Subject: Request for Additional Information

Our ref: Marulan South Limestone Mine - Traffic Management Plan (SSD-7009-PA-23)

I refer to the Traffic Management Plan (Revision 2, dated 4 May 2022) submitted to the Department of Planning and Environment (the department) as required under the conditions of consent for the Marulan South Limestone Mine. After careful consideration, the department is requesting that you provide additional information.

Figure 1
Transport route

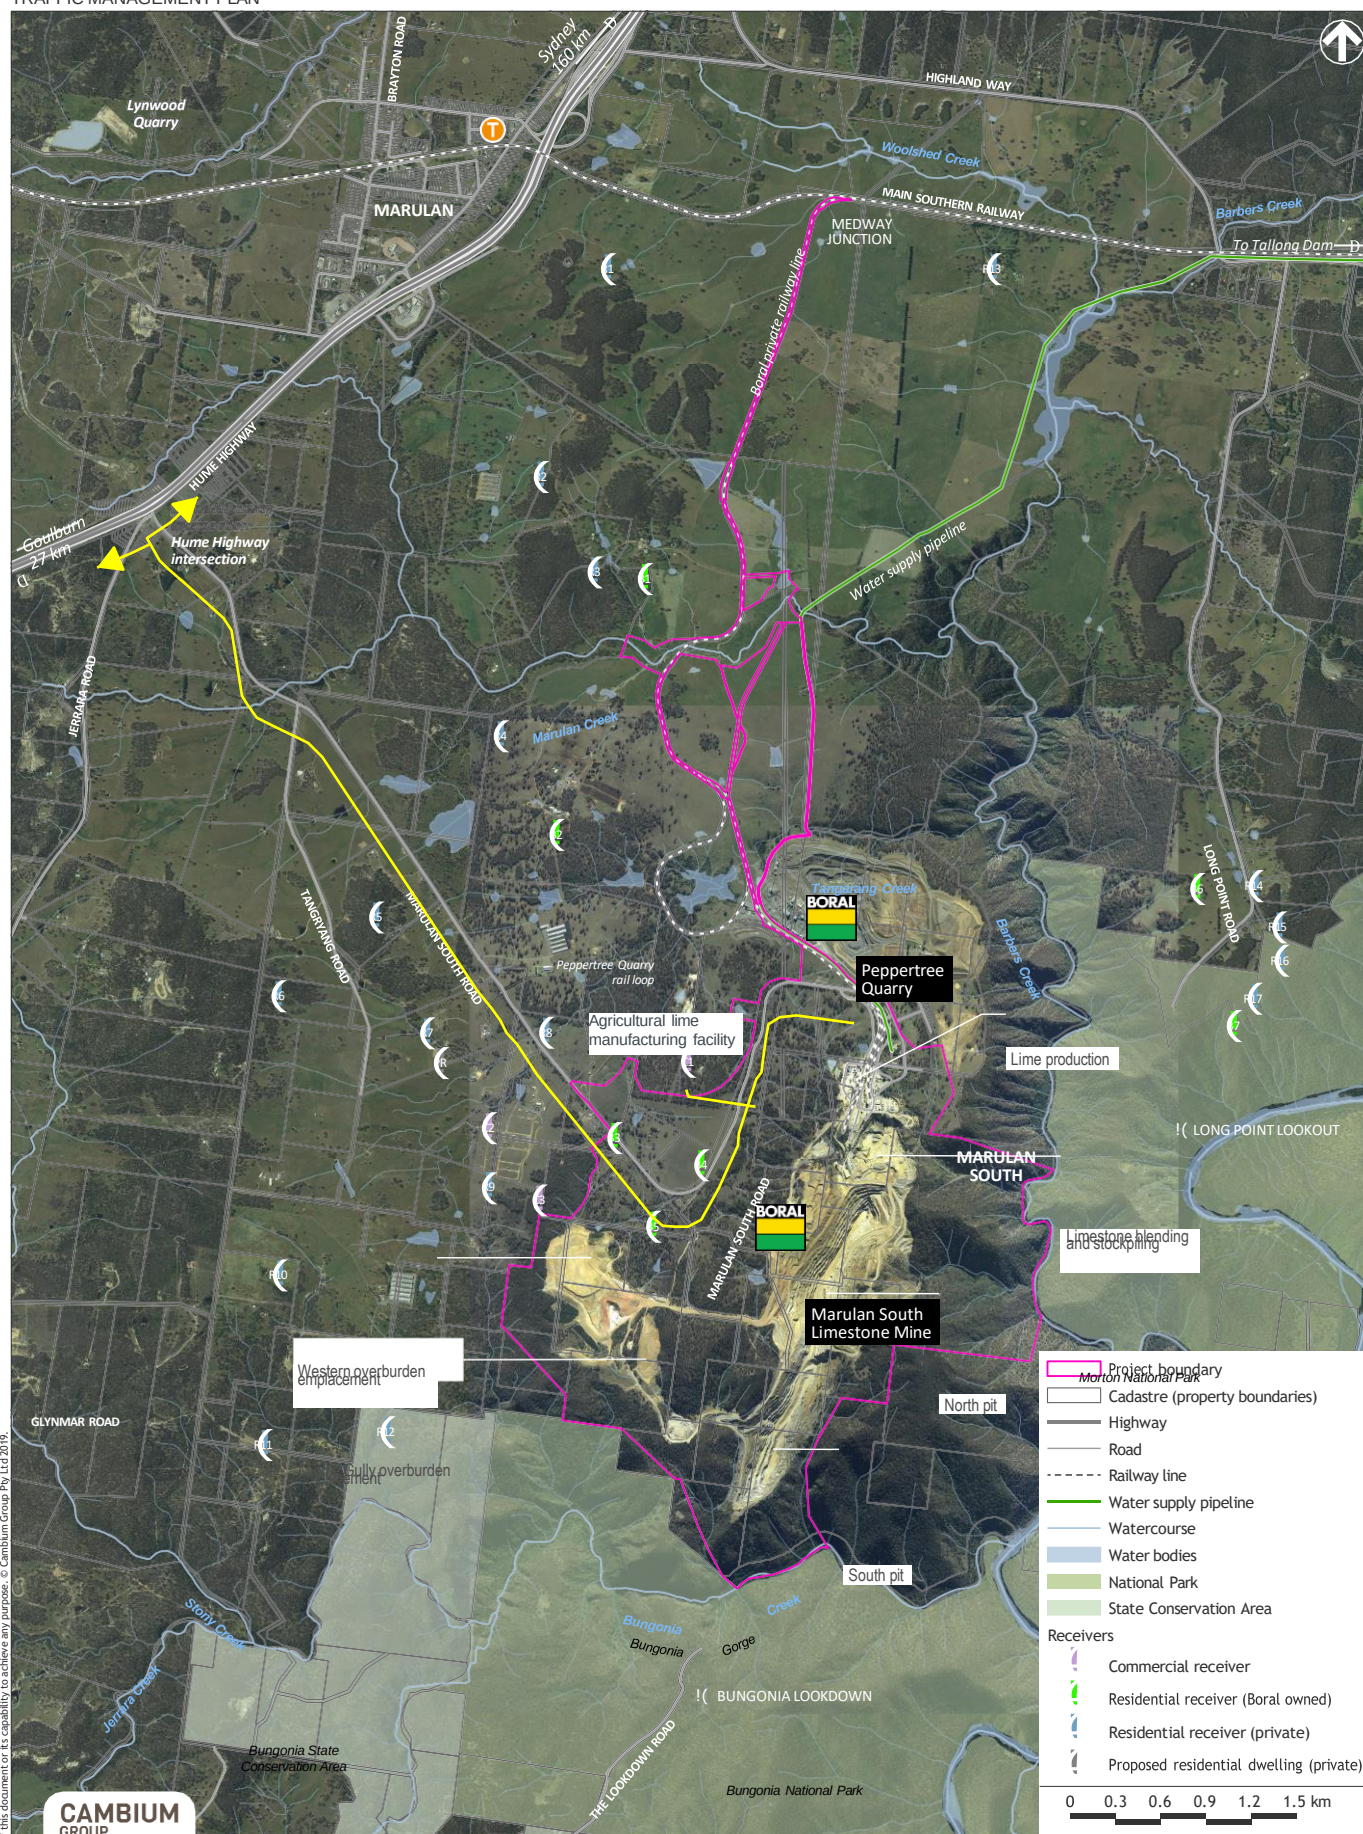
- As per condition B90 (A) of the consent, Boral is required to include details of all transport routes and traffic types to be used for development-related traffic. In addition to the information Boral has supplied in Section 3.3 of the Traffic Management Plan, please provide route details from the identified site to the nearest state road. If required, please supply further information detailing if any development-related traffic is exiting the state road to access regional centres such as Berrima. This information must include a simple marked up map with a small description.
- Please correct the typographical error, in highlighted yellow, under section 6.1 of the Traffic Management Plan, as per condition D11 of the consent.
